PLANNING BOARD REPORT PORTLAND, MAINE

MMC East Tower and Visitor Garage Vertical Expansion and Relocation of Helipad 22 Bramhall Street Level III Site Plan Project # 2017-289 Maine Medical Center, Applicant

Submitted to Portland Planning Board:	Prepared by: Jean Fraser
Public Hearing Date: March 27, 2018	Date: March 23, 2018

Visitor Garage Expansion

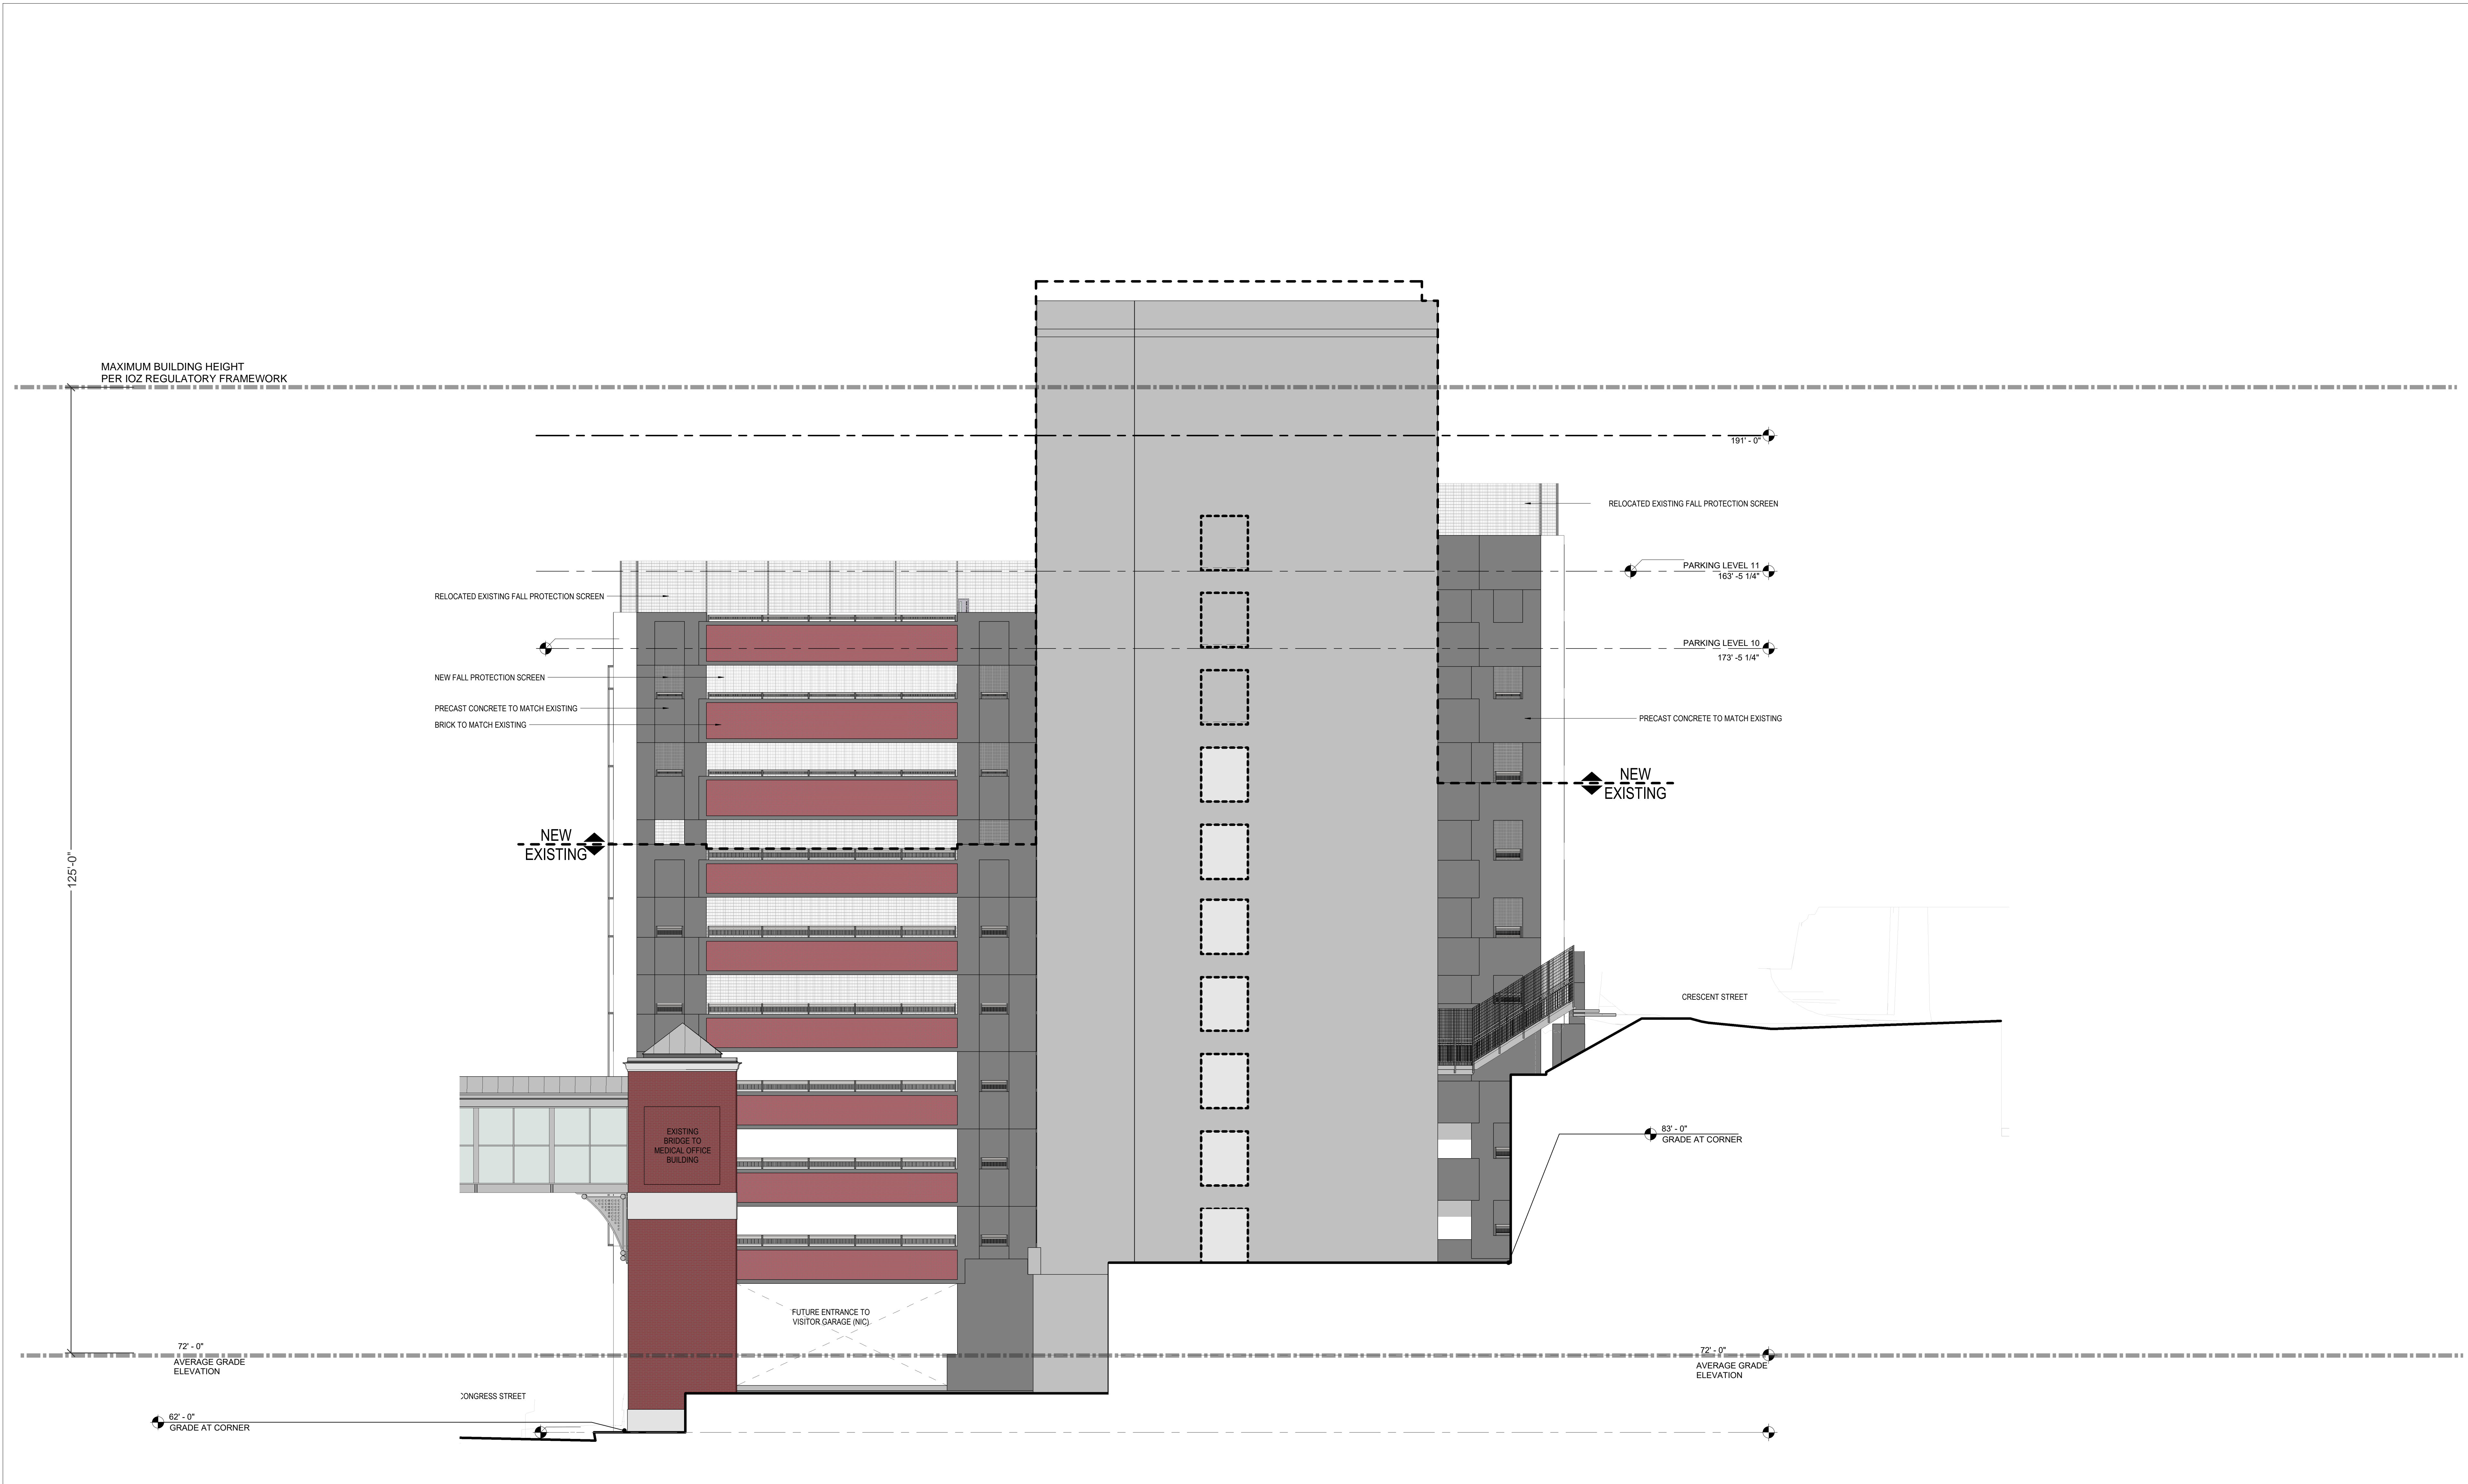
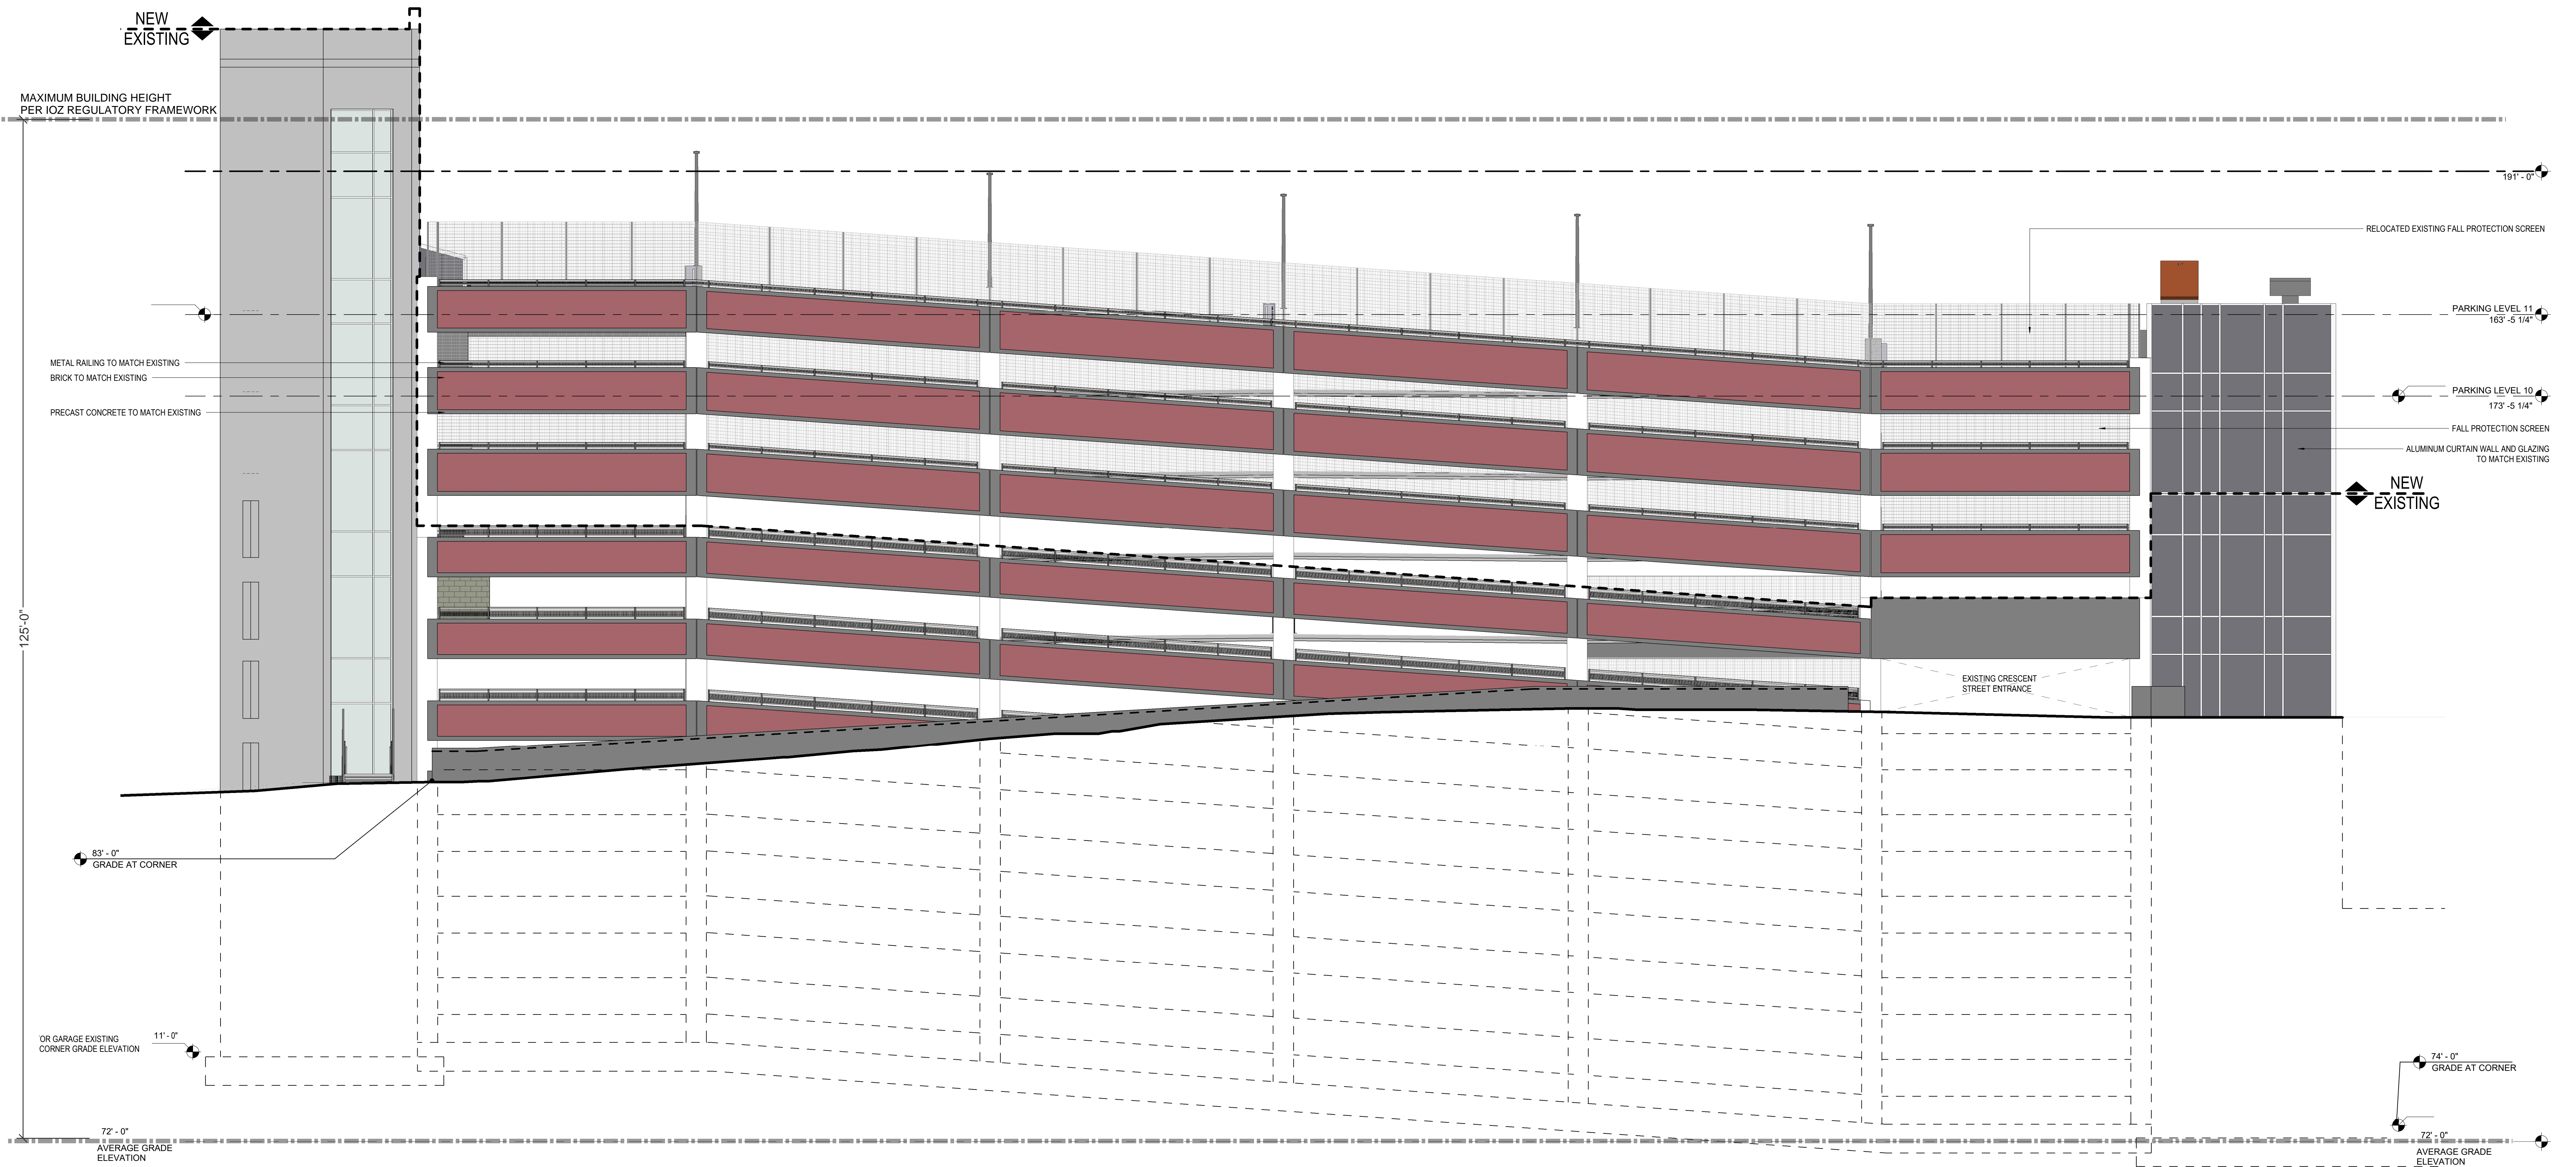
PB comment	Response
 Design - comments regarding the East Tower included: Looks like new building on top; Looks glaringly institutional; Seeking more cohesive- more integration Would like more info on how the white wall of the ET expansion will relate to other new buildings Would like to see renderings with other colors (?silver)/options for Board to consider Requested rendering of ET from long view 	 Staff met with MMC on several occasions to better understand the options they had considered and the constraints. The applicant submitted a "<i>Design Review Update</i>" (<i>WS Q -2 2.23.18</i>) and amplified on this at the second Workshop (<i>Presentation WS S - 13</i>) and recently submitted <i>WS Q -3 Design Review Update 3.23.18</i> to clarify the design process and respond to comments.
Would like to see details of visitor garage fencing and other fall protection; also seek roofline articulation	The Hearing submittal includes a revised garage treatment that largely hides the fall protection fencing (See <i>Hearing Plans B a</i>).

(d) Dimensional Requirements - Maximum Building Height: Visitors Garage: 125 feet (the IDP indicated a future height of 119 ft)	Submitted proposals indicate a height of 119 ft excluding part of the stair tower	Appears to meet dimensional requirements as stair and elevator overruns are considered appurtenances. Additional information was received which confirms height is 119 feet
